Office of Environment & Heritage

10_0054 MOD 4
DOC18/938066-3

RE: Modification Application for Dargues Reef Gold Mine (10_0054 MOD 4)

As requested, we have reviewed Dargues Reef God Mine fourth Modification Application (Mod 4) and advise the following:

**Figure D**  
**VEGETATION COMMUNITIES**

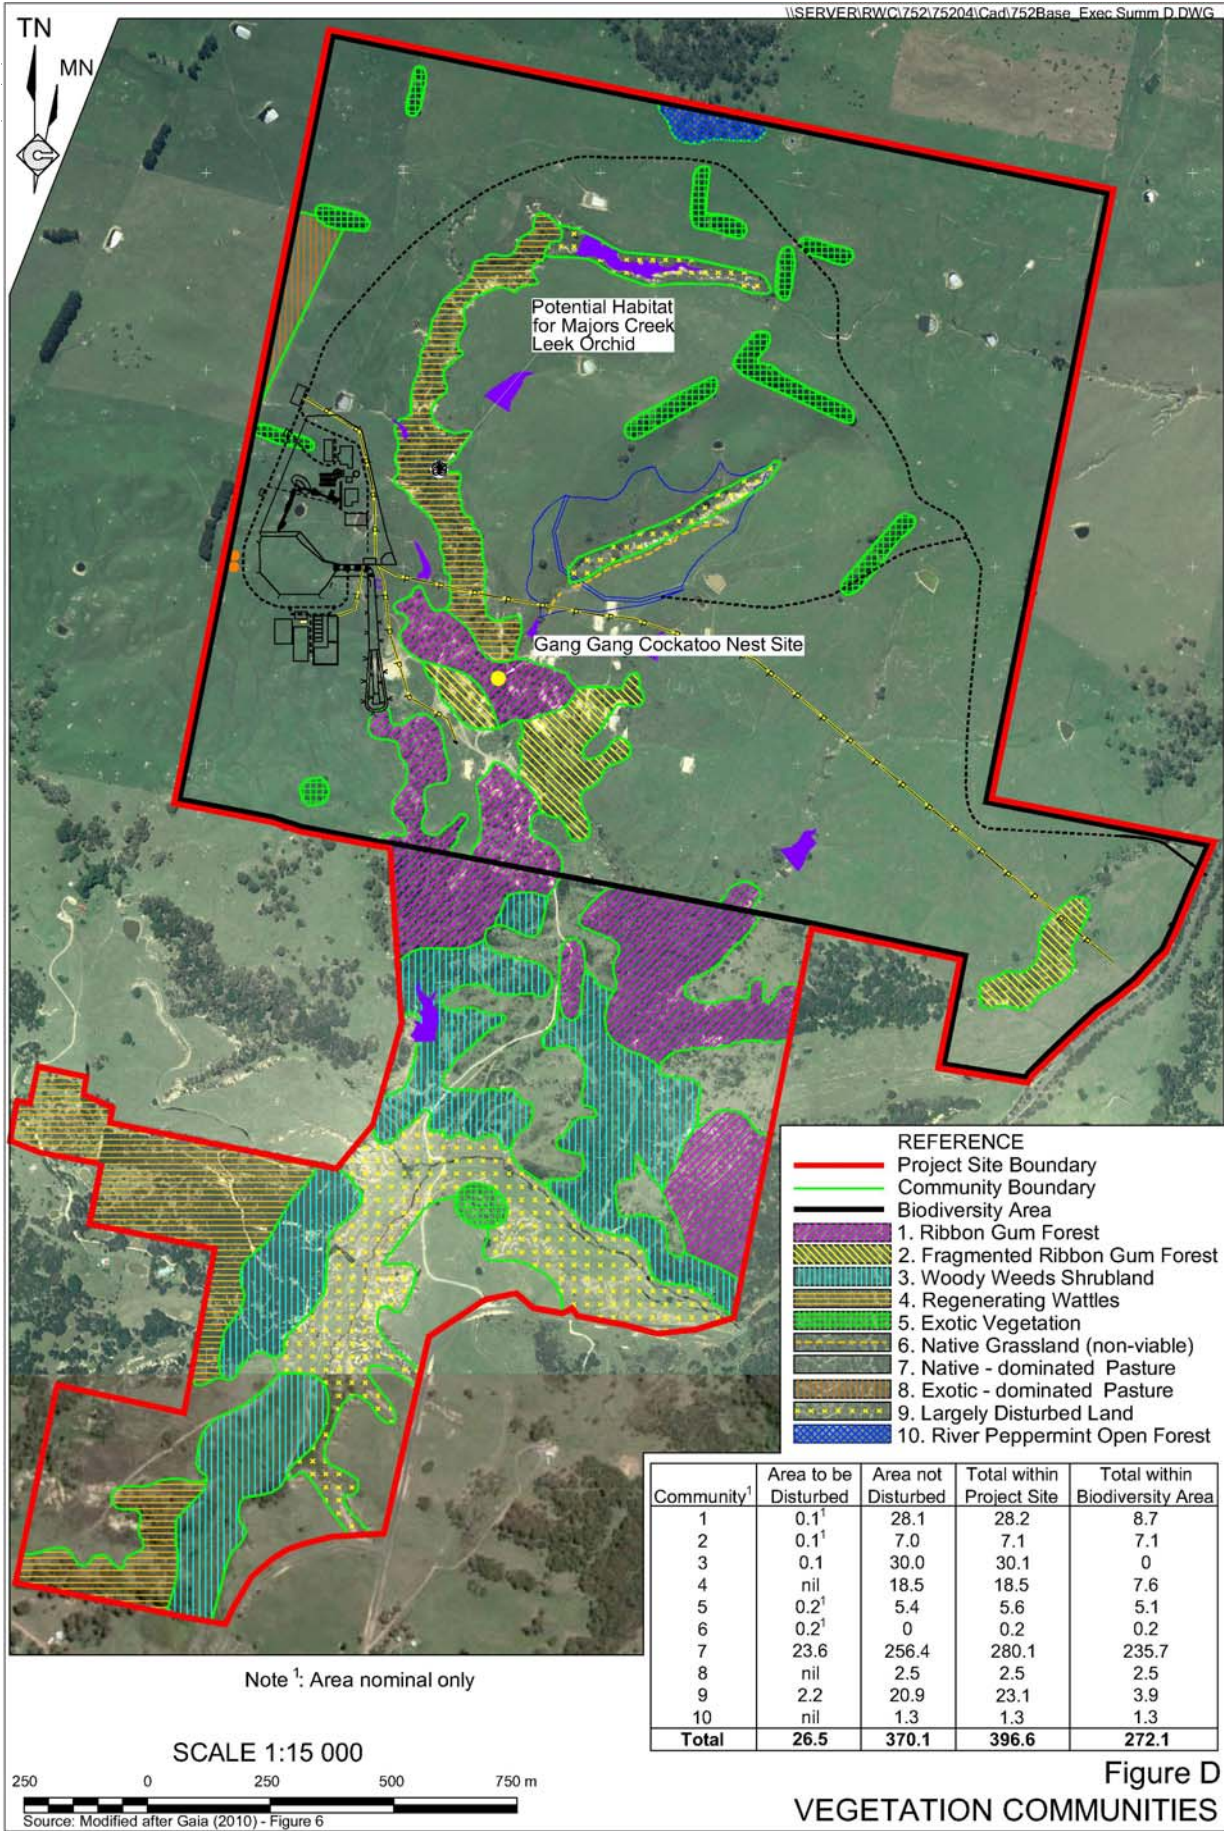
The SEE states that this modification is different and less impact from the previous modification. However, it does not provide any information to validate this statement. We therefore recommend the proponent be required to provide sufficient information to determine whether the modification will not increase the impact on biodiversity values.
